17th August 2012

Re: Discovery Point Neighbourhood Park - Application to Modify Project Approval
Review of Park Growing Conditions

GARRY CLUBLEY

Arborist and Landscape Consultant

Elevation AA - Neighbourhood Park

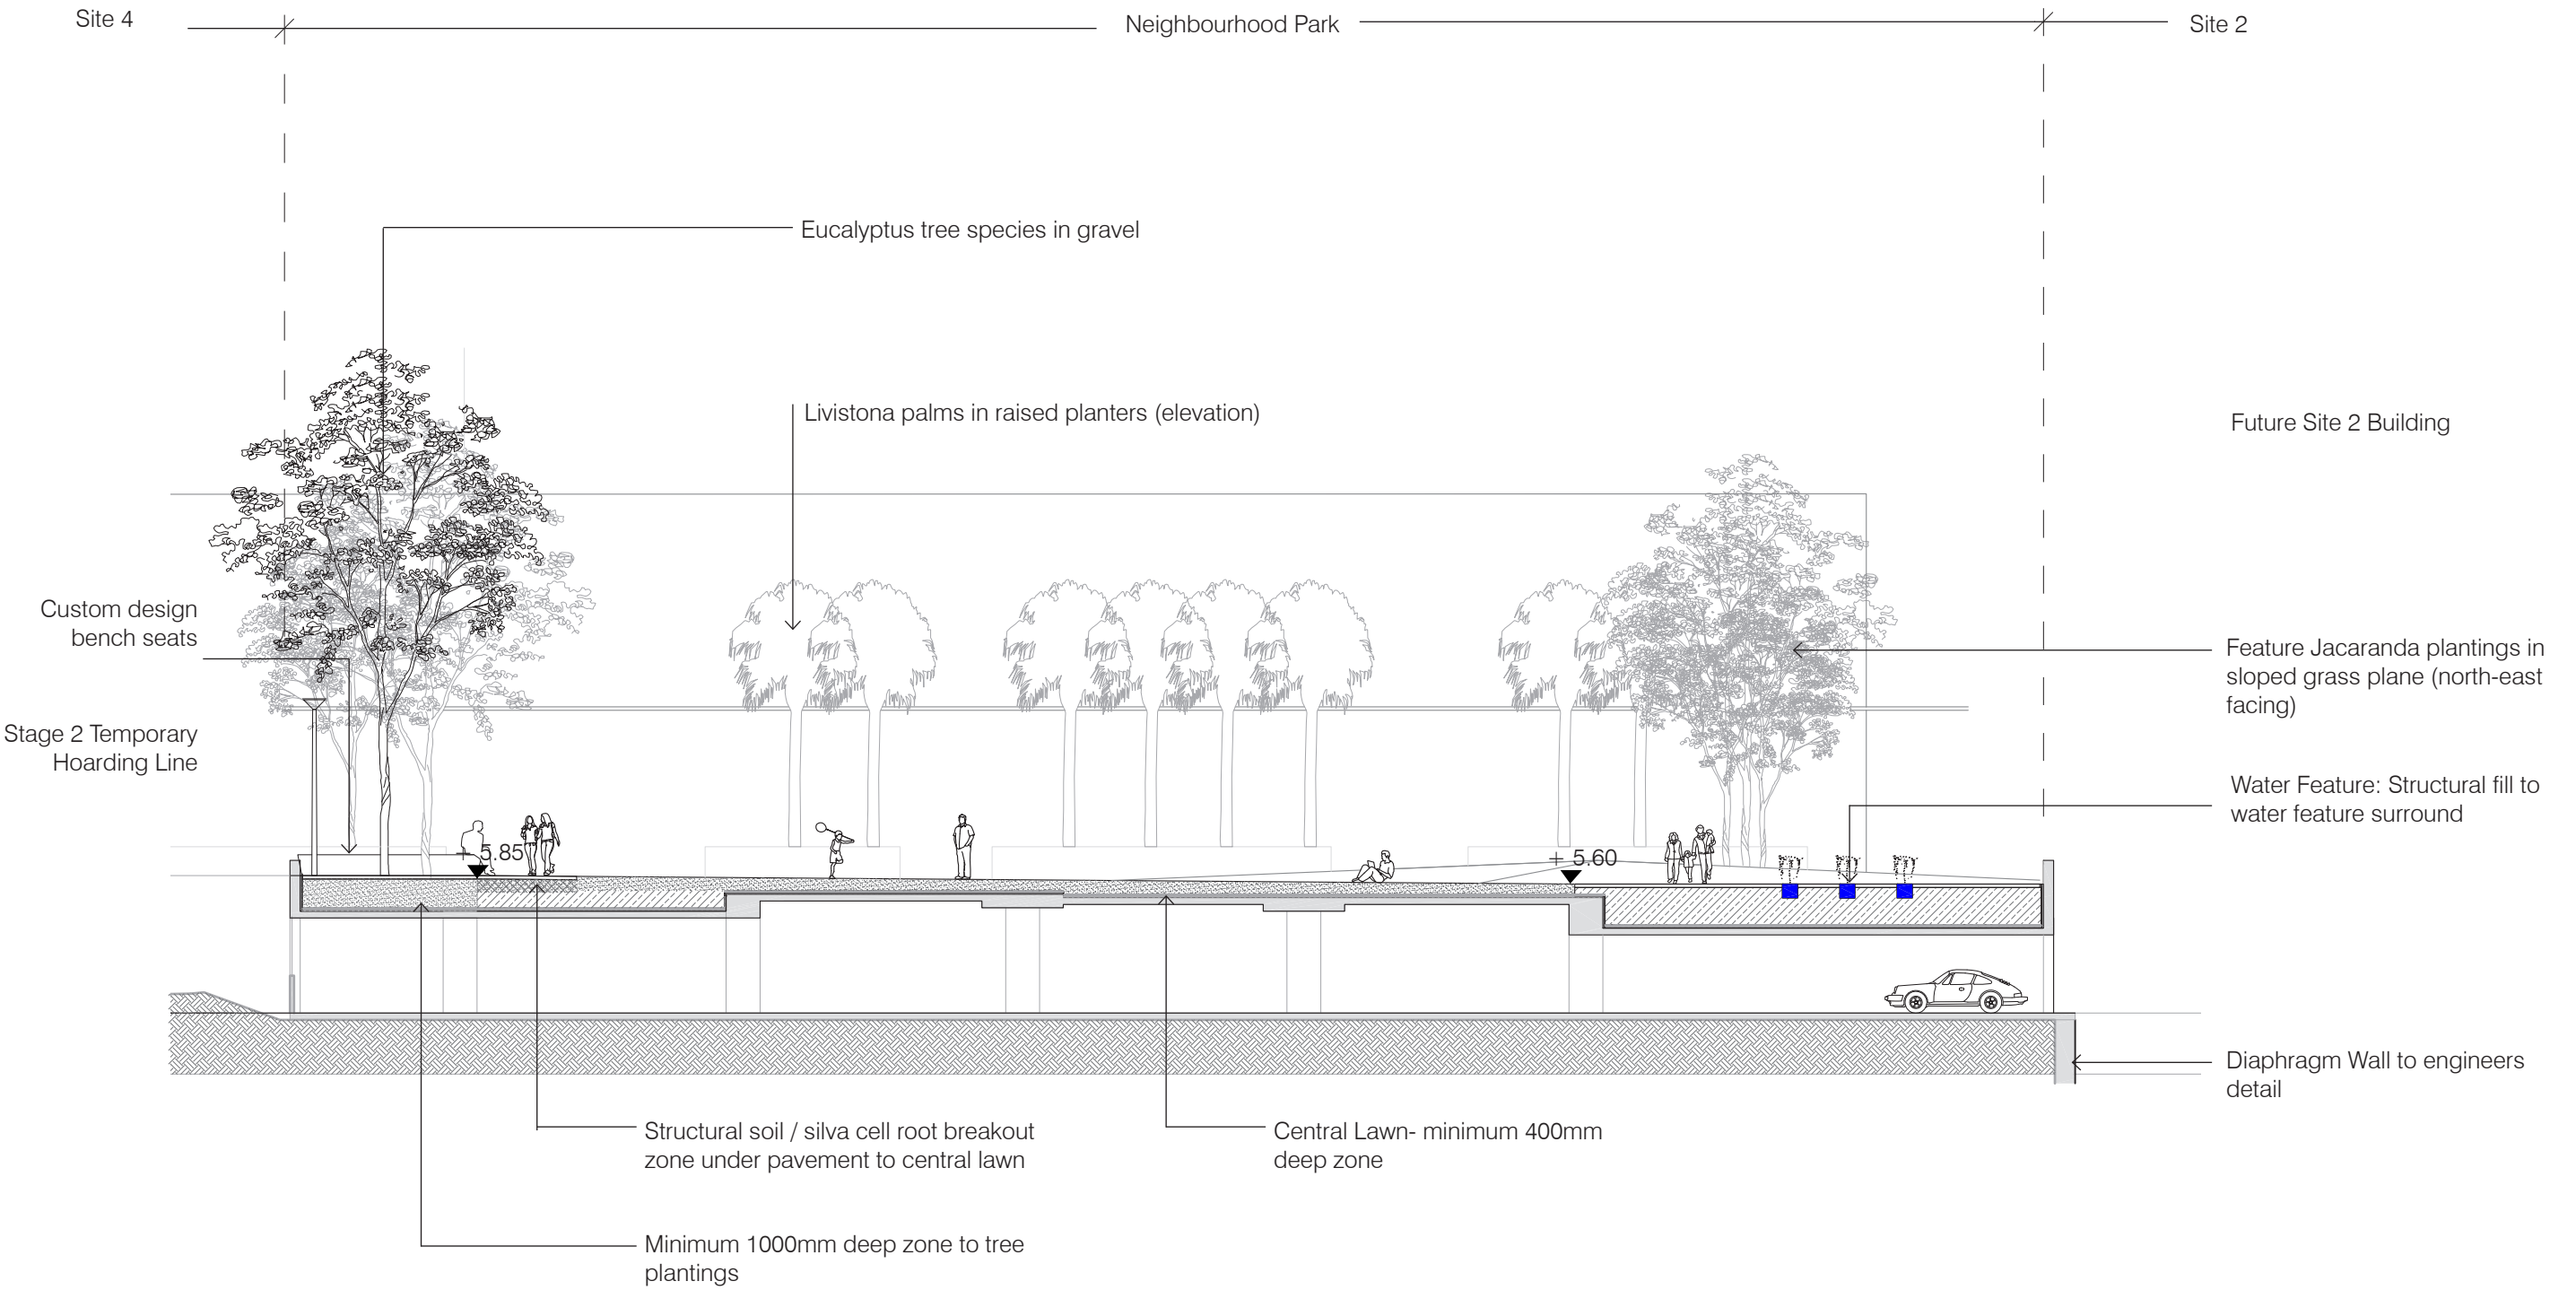
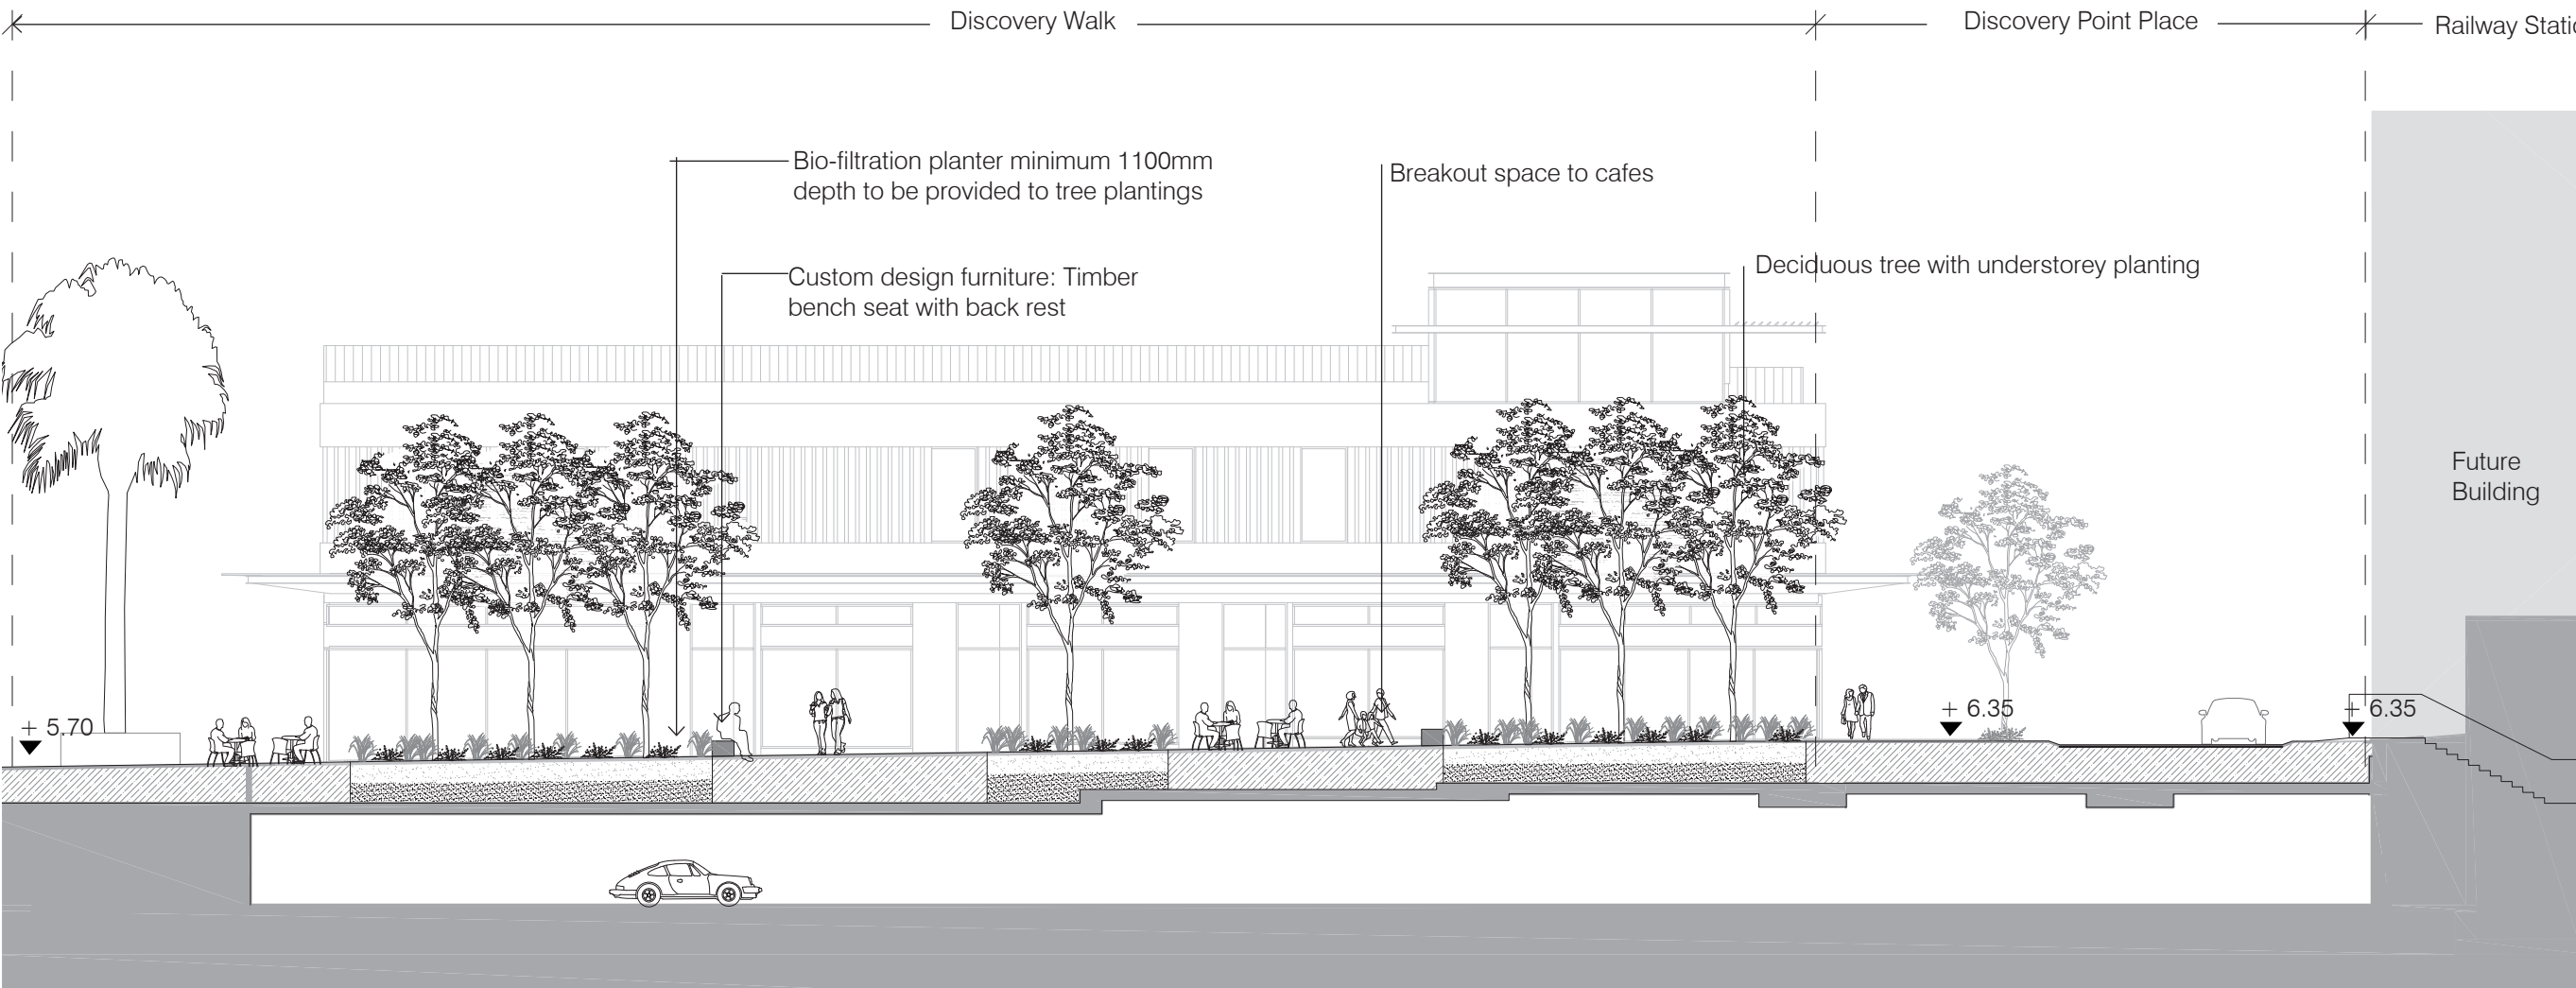
- 4.1 Soil depth is critical to the eventual mature size of the three tree species and to their stability. I understand that the preferred design is a terracing beam slab rather than the previous upstand beam design. In principal a terraced slab does not necessarily affect tree growth if adequate soil depths over most of the slab can be achieved. Similarly, the vertical face of each terrace slab should not necessarily restrict root development into the turf area if there is adequate depth of soil over. Typically, tree roots will grow up and over or be deflected by what ever structures exist below the soil surface. A review of the current structural concept drawings indicates there will be adequate soil depth over all sections of the slab for each planting element.

- 4.2 I note that the SESL recommendations for turf areas indicate a total profile depth (including drainage layers) of 400mm. I agree with this, as actual soil depths less than 300mm typically result in stress in the turf due to cycles of drought and saturation. If there is no irrigation for the turf, then a soil depth of at least 300mm or greater permits grass roots to grow deeper and survive extended periods of drought. The greater depth also provides grass with improved resilience to wear and faster recovery. These aspects of turf performance should also be addressed in the maintenance regime to be implemented for the park

- 4.3 The current design details show the indicative soil depth in tree trenches as 1 to 1.1m. Allowing for the subsoil drainage system and the characteristics of soil moisture migration through the profile (described below in Item 5.3), the effective soil depth will be 0.9 to 1m. This is consistent with the SESL recommendations and is appropriate to establish stable root growth and to support longer term growth.

NEIGHBOURHOOD PARK - CARPARK EXTENSION SOIL PLAN
1:200@A1 / 1:400@A3

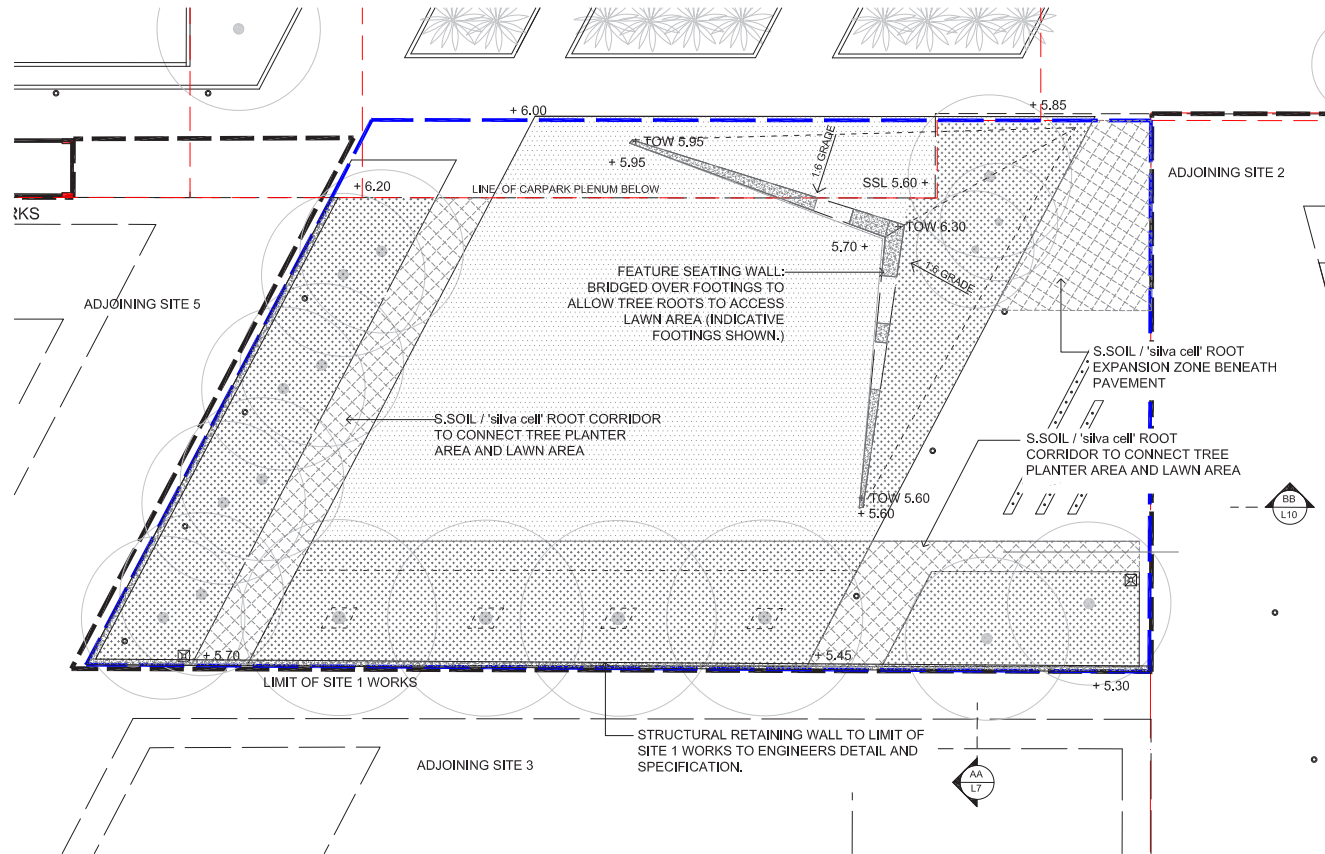
- 5.1 The soil volume available to tree roots is critical to the longer term performance of the trees. A review of the drawings shows continuous trenches of 6m to 7.5m width and up to 1.1m depth. The latter effectively being reduced due to the saturation zone in the lower soil profile (see Item 5.3 below). Drawing S01-L-403 indicates 446m³ for the combined Plane Trees and Scribbly Gums. Although soil volume for both species will be reduced by sub-soil drainage. Assuming there are no below ground barriers to the tree planting areas, the overlap of the planting trenches will act as a shared rootzone.
- 5.2 Through the use of suitable growing media beneath pavements, the effective

- 5.6 I would strongly argue to maintain the width of tree trenches. The further the grass is from the base of the trees, the better the longer term tree health and growth.

- 10.1 At this stage I am not aware of other constraints that may limit the total soil volume or soil depth available to the trees. However, I would expect that there will be various services and conduits located on the concrete slab and within the soil profile. Ideally, these should be located well away from the tree trenches so as to avoid conflicts with tree roots and to reduce impacts on trees in the future if services have to be dug up.
